**Planning Application Ref:** AL/64/20/PL

**Location:** Springfield, Hook Lane, Aldingbourne, PO20 3TE

**Description of works:** Demolition of the existing dwelling & construction of 2 no. 2-bed. 3 no. 3-bed, 4 no. 4-bed houses including access, landscaping & associated works (resubmission following AL/27/20/PL).

Drainage Strategy				Draining The
Engineering Details				
Drawn	Checked	Scales	Paper Size	Date
JN		1:250	A1	08.19
Job No.				Revision
KNC/1932	602-01			C

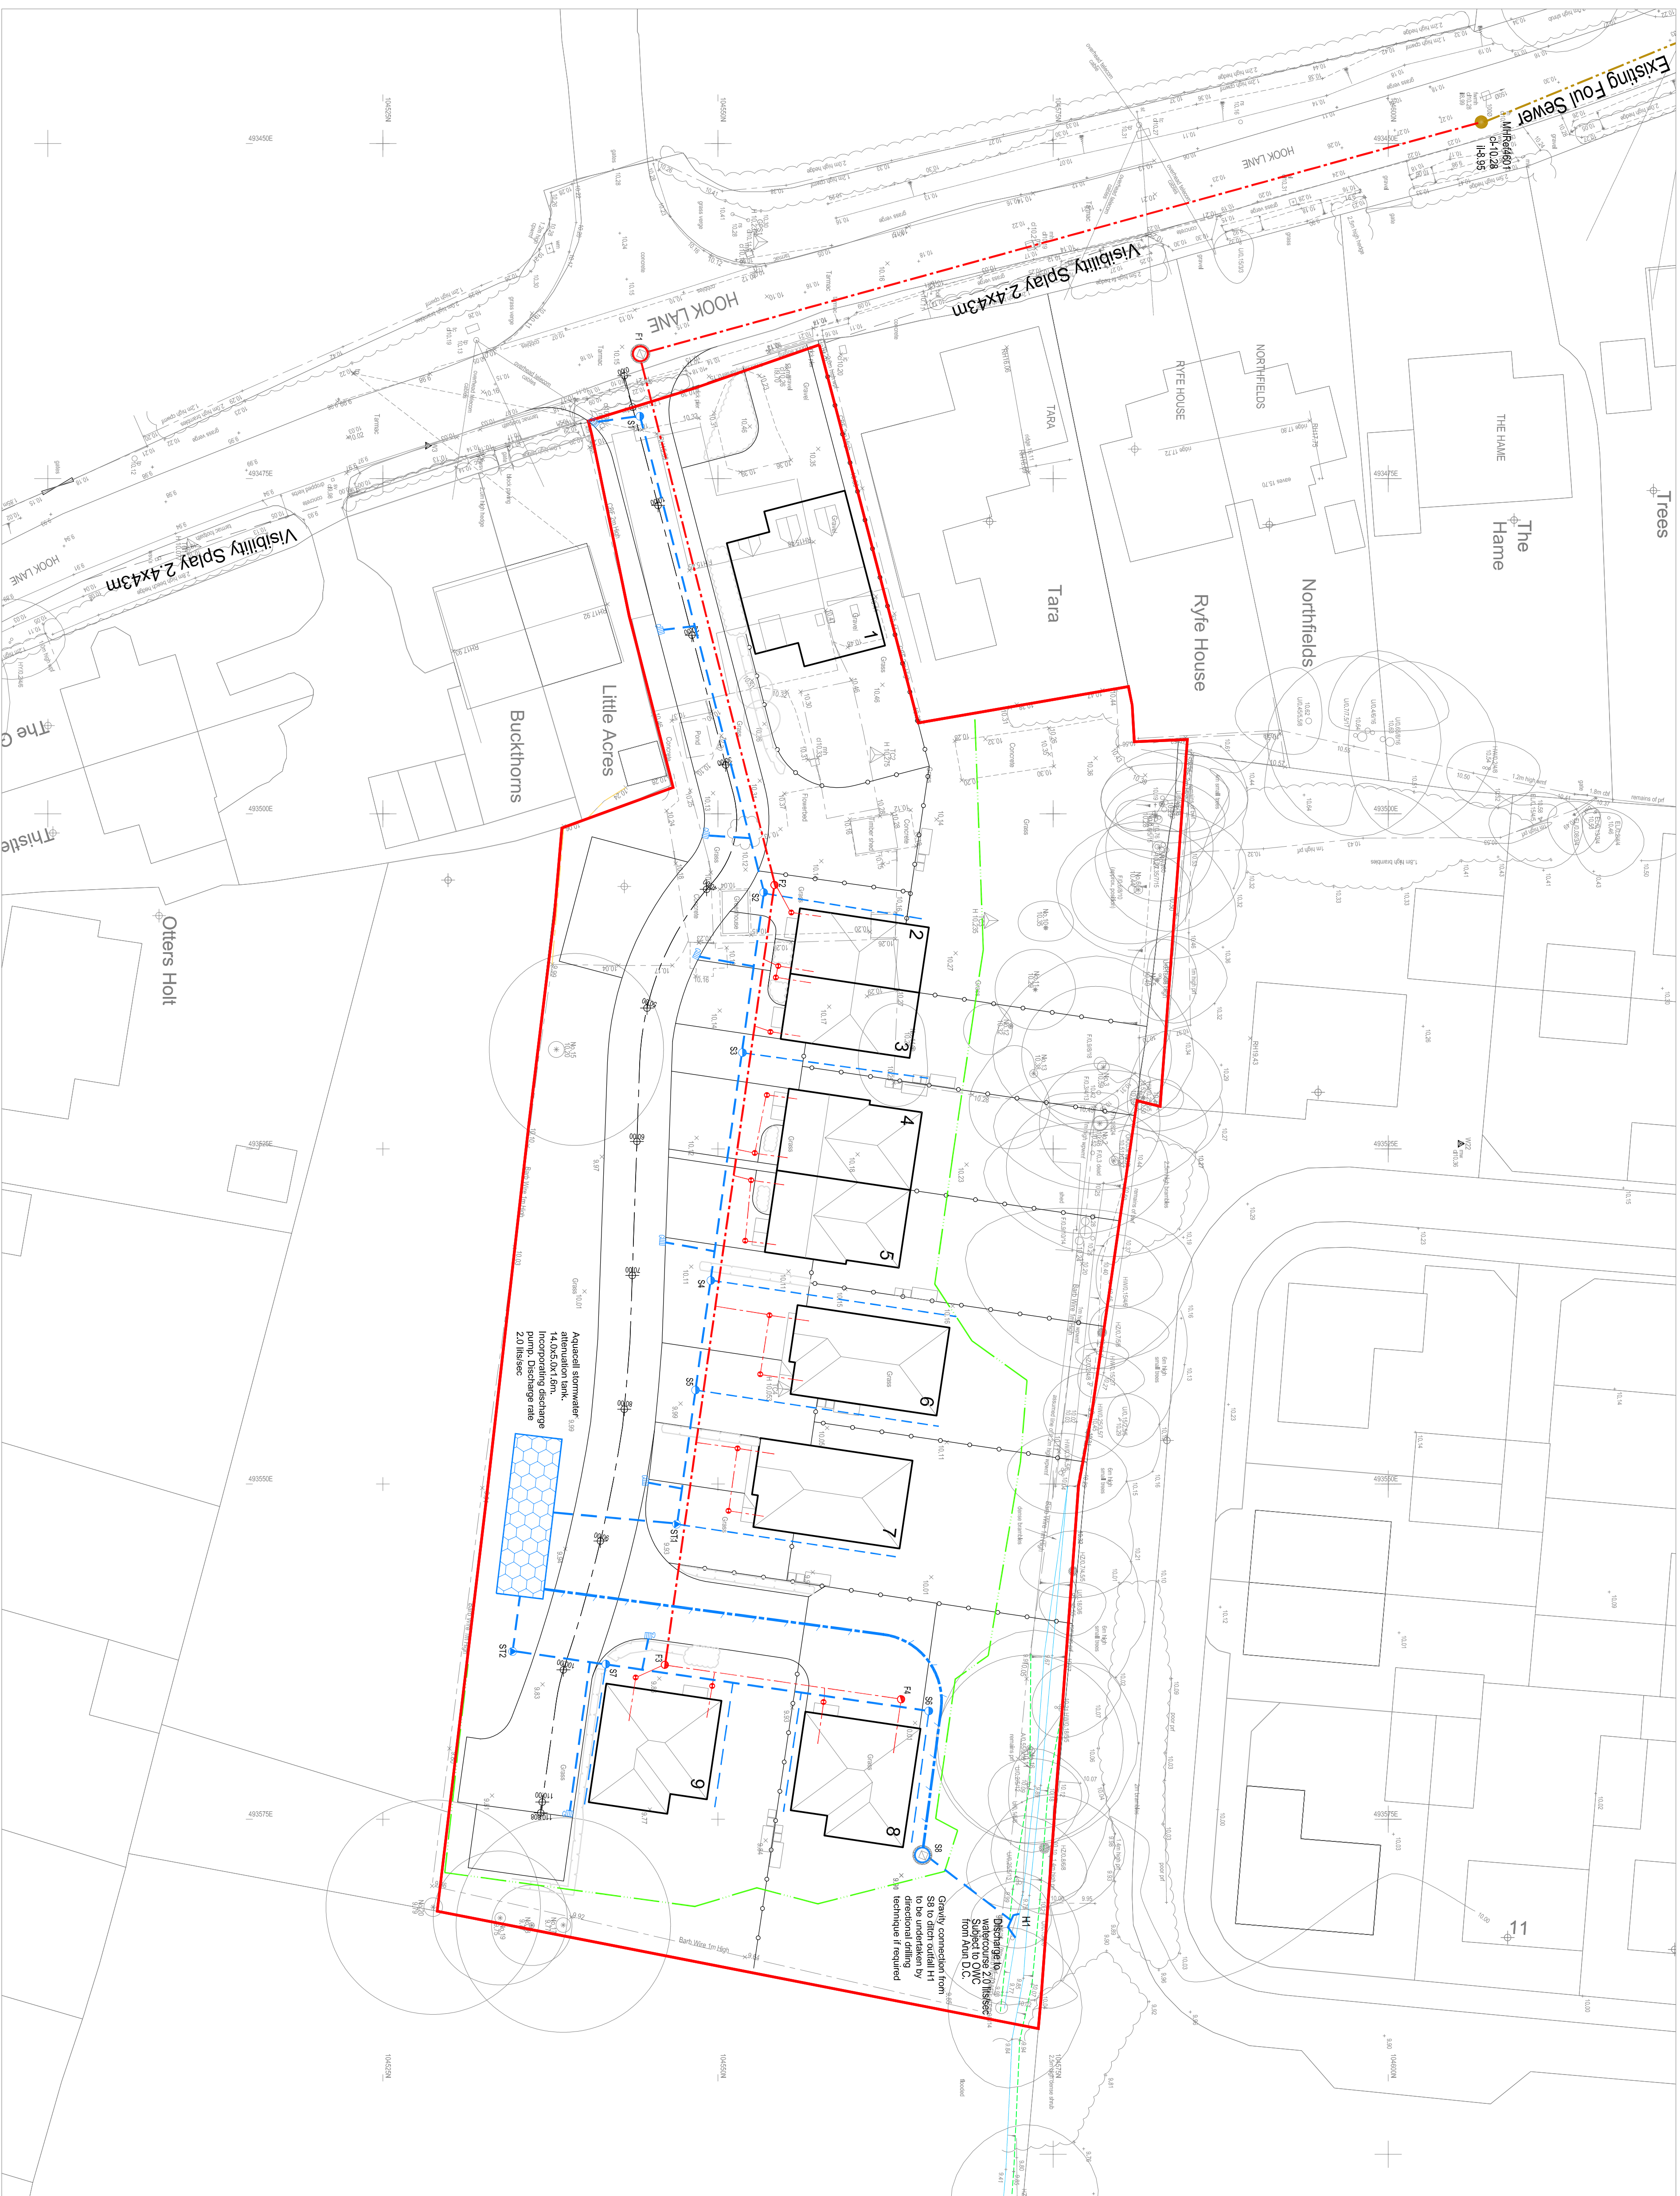
- The Engineering Details Drainage Strategy for the site as illustrated (dwg. no. 602-01, Rev C) is broadly respectful of retained trees and their growth potential, with the obvious exception being chosen route of surface water discharge to the north boundary watercourse and construction of headwall – both within the RPA of retained (off-site?) mature Cypress T21. Directional drilling technique is proposed '*if required*'. I say it is necessary unless exploratory excavation findings permit standard trenching. All that to be set out in the required Arboricultural (Impact Assessment &) Method Statement. Might it not be easier to take a more northerly route from manhole S8 and avoid significant tree's (T18 & T21) RPA altogether, subject to suitable ground levels (gravity connection)?

- **Drainage Strategy needs to be re-considered in part** and must be approved in association with the overall layout, to ensure adequate safeguarding of retained trees.

- **UNRESOLVED.** I have read the Arboricultural Impact Assessment and Method Statement, LLD1680, Rev 04. There is no confirmation or even suggestion that my concern relating to the proposed Drainage Strategy and its potential negative impact on 3<sup>rd</sup> party tree (T21) have been properly addressed.

Drawing No	Revision
LLD1680-ARB-DWG-002	08
CAD Filename	
LLD1680-CAD-ARB

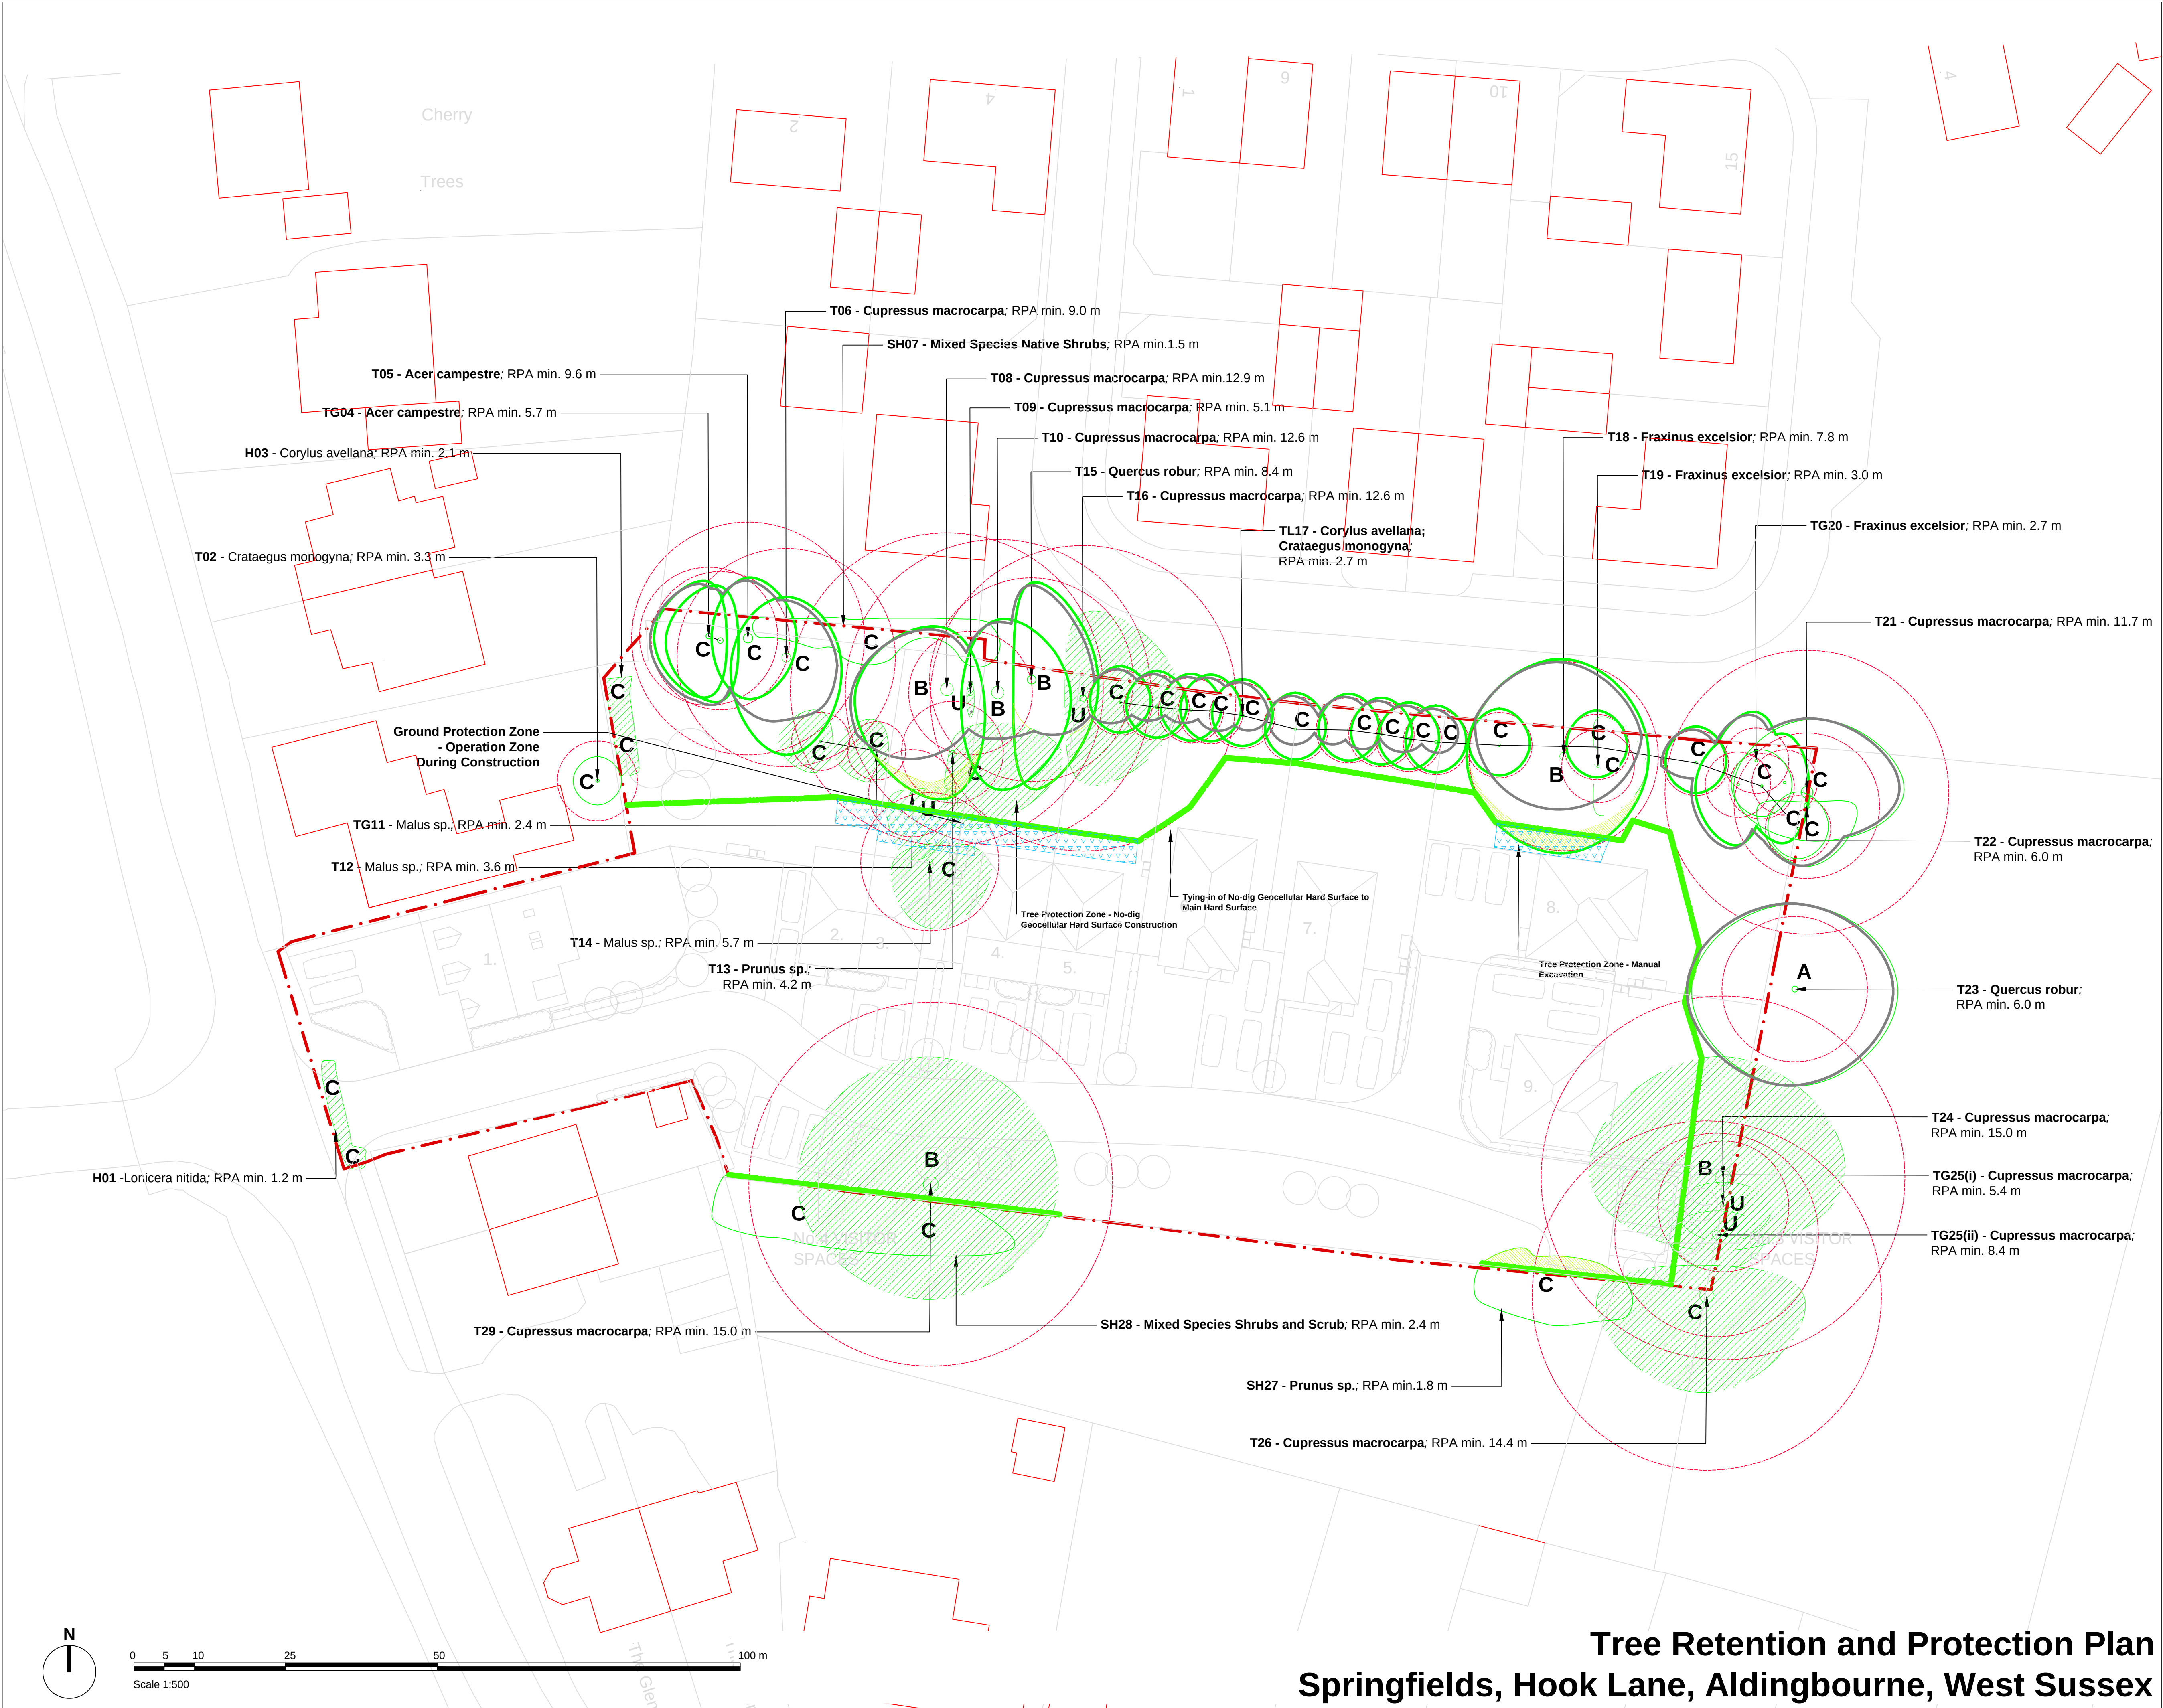
- I have considered this application by means of a desktop review, using the information and plans submitted as well as online resources.
- The applicants have employed **Lizard Landscape Design Ltd** to prepare a Tree Retention and Protection Plan for this project, but without a supporting Arboricultural Impact Assessment & Method Statement - a requirement of BS5837:2012. As such, were this application to now proceed, we will not have sufficient information to guarantee such trees would be adequately respected and protected.

- In broad terms, the proposal as it stands can be implemented by retaining the majority of large evergreen trees, that are of obvious landscape value. A number of these have also been identified as Category B trees, a rating I can comfortably support. It is therefore disappointing there is no attempt to retain T24 & T29 Cypress when they could be in harmony with the dwelling (plot 9) and access road, by selective branch shortening and if a 'No-dig' construction method was employed. That said, neither is suitable for a Tree Preservation Order and so we cannot prevent their removal, although I would expect to see adequate mitigation.

- The proposed removal of T24 & T29 is unfortunate. The important tree line along the north boundary is suitably accommodated and with far less intrusion into likely rooting zones.
- We need to see a detailed landscape plan inclusive of tree planting proposals to ensure adequate mitigation for the loss of so much high canopy.
- **RESOLVED.** Agree that this can be resolved with a pre-commencement condition, subject to support from our Leisure and Landscape Officer.

- **RESOLVED.** We now have the necessary AIA/MS which supports the previously submitted Tree Protection Plan.
